Application number: 2023/90444	
What is the application for?:	Erection of detached dwelling
Address of the site or building:	Land adj, Fern Bank, Far End Lane, Honley, Holmfirth, HD9 6NS
Postcode:	HD9 6RP

Type of comment: An objection	
Do you wish your comments to be published on the website anonymously?	Yes

Proposed Ground Floor Plan - 1:100

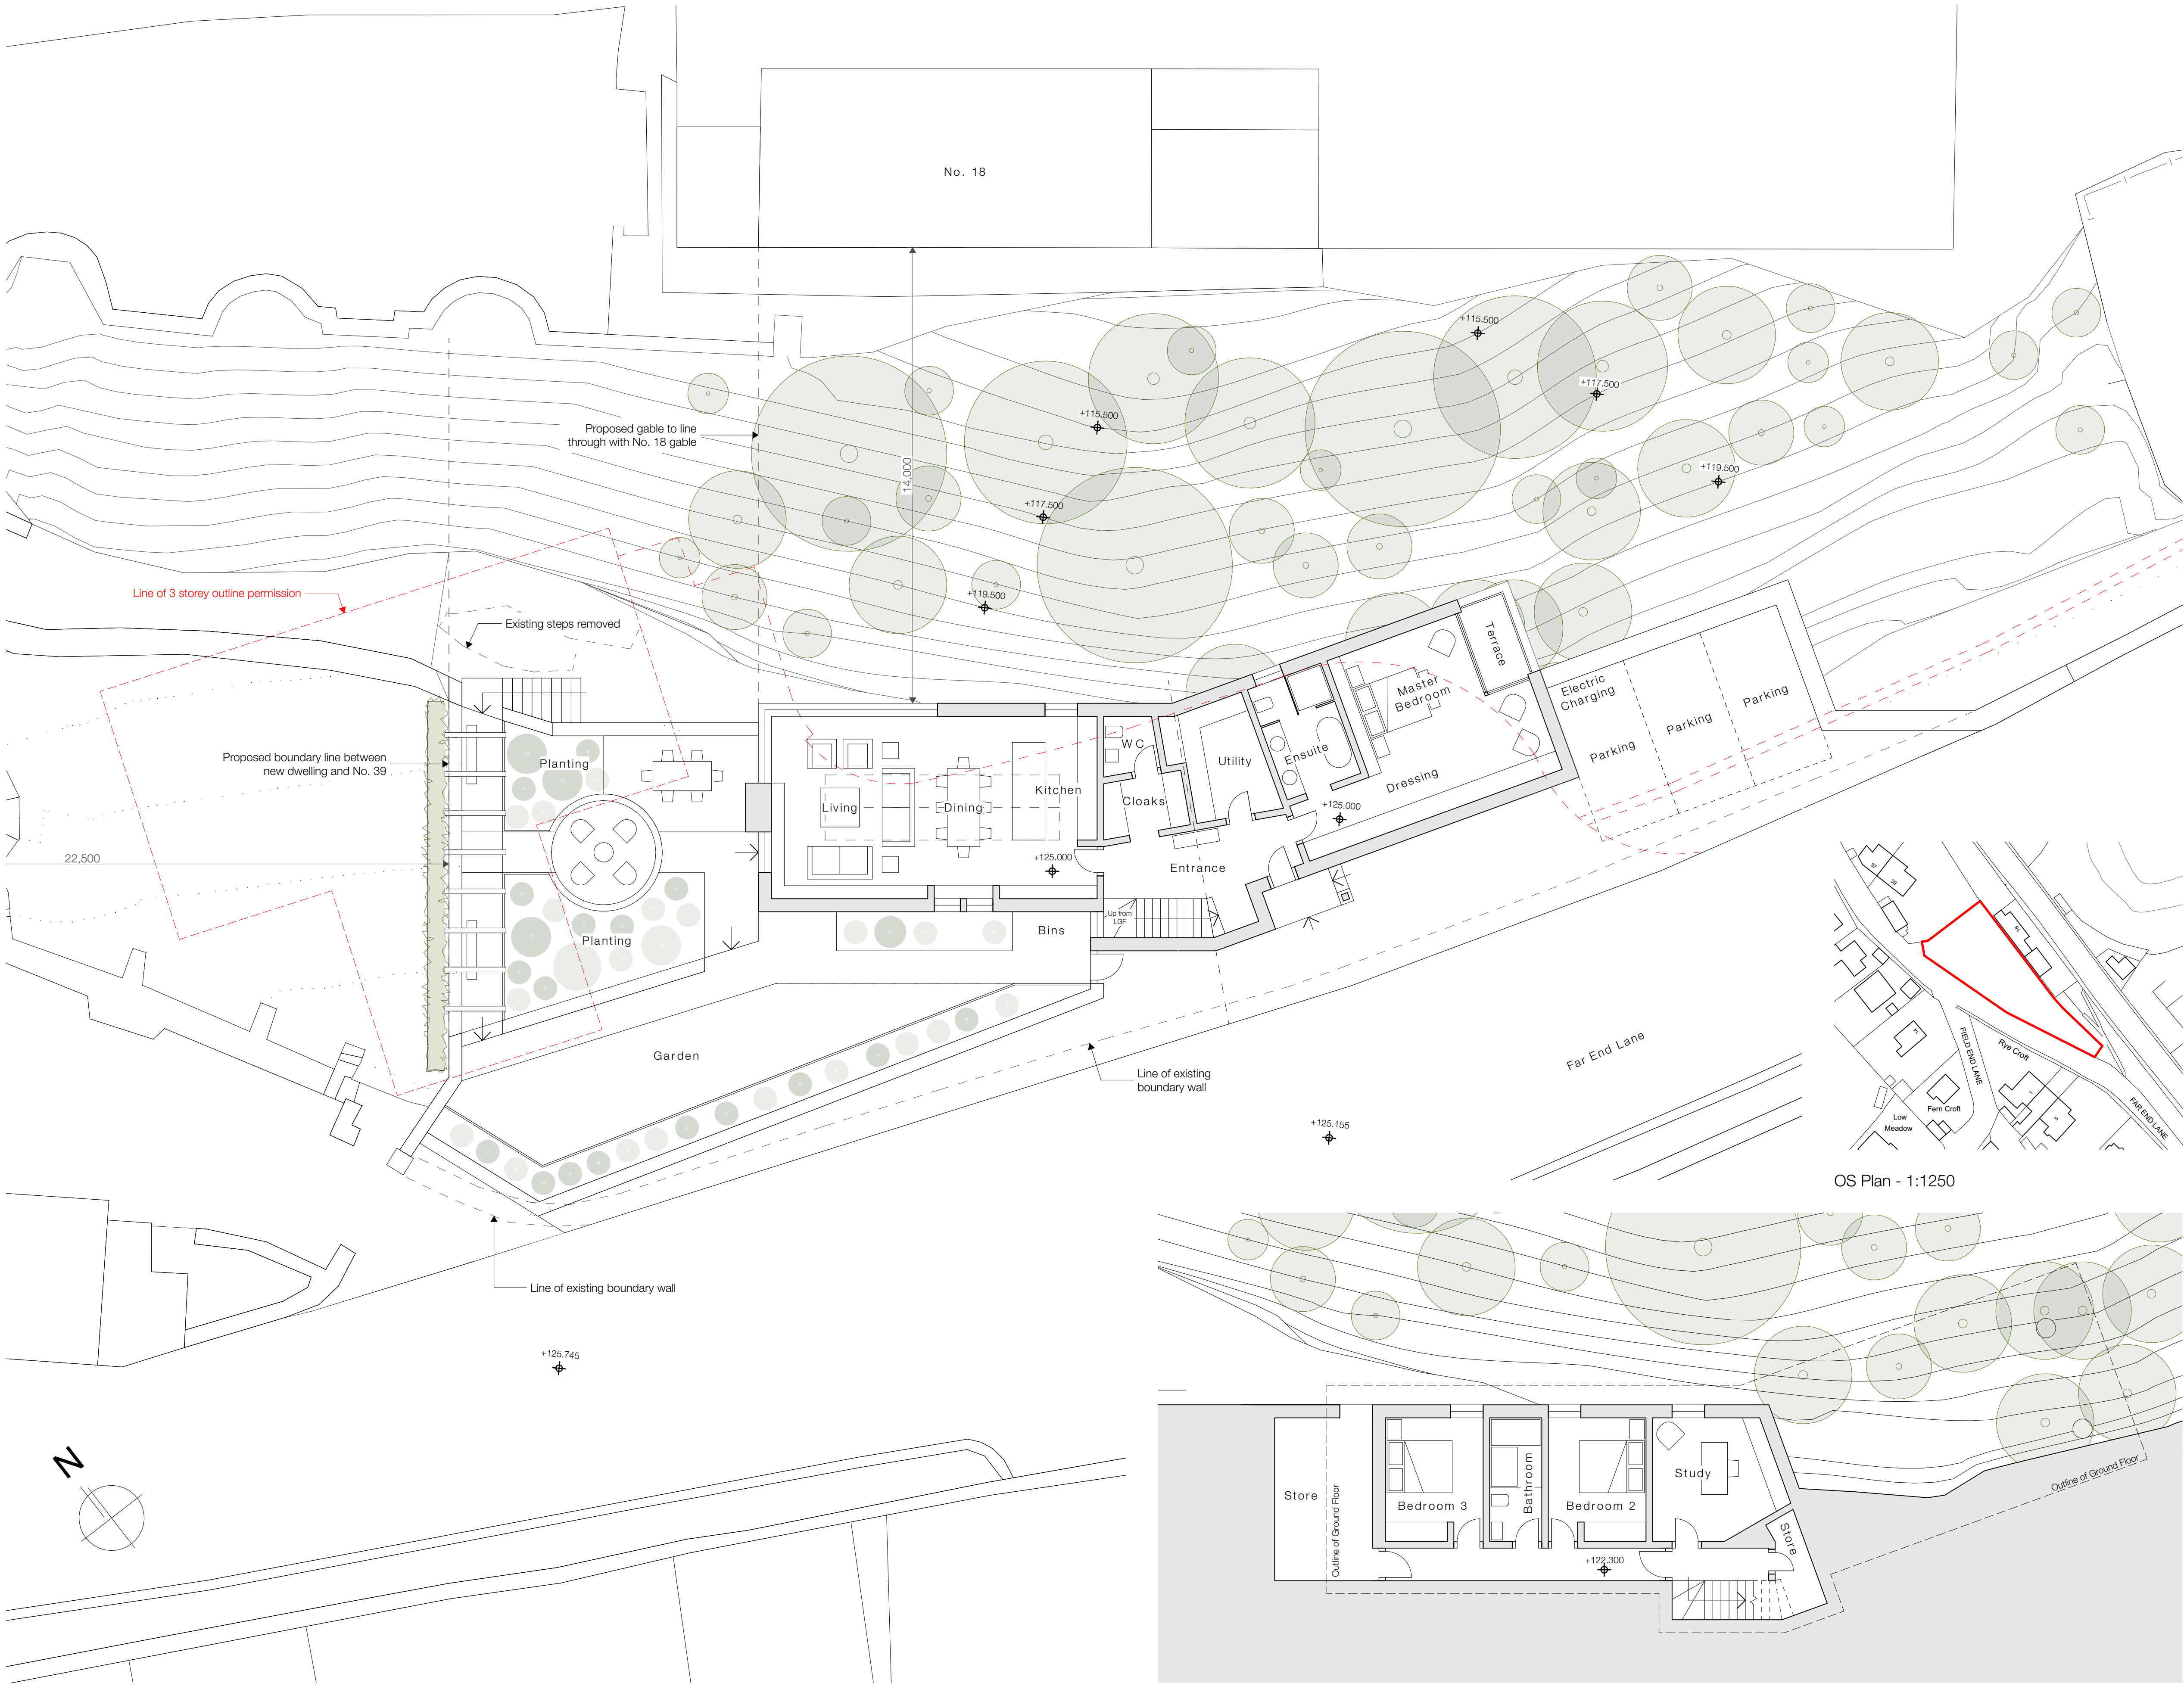
Condition 13 of the outline permission 2019/91370 required the 'provision of a 2-metre-wide footway across the site frontage.' The Delegated Officers Report referred to it being 'a key requirement' for development at this site.

It is disappointing that this application for full planning provides NO footway across the site frontage and not surprising that this has led to objections by neighbours and HV Parish Council.

The omission of this 2m footway demonstrates that the applicant is at odds with relevant Local Plan policies which require designs to prioritise pedestrians.

A new footway would also provide a safer environment for pedestrians at the new dwelling - the occupants and visitors – rather than having a boundary at the carriageway edge.
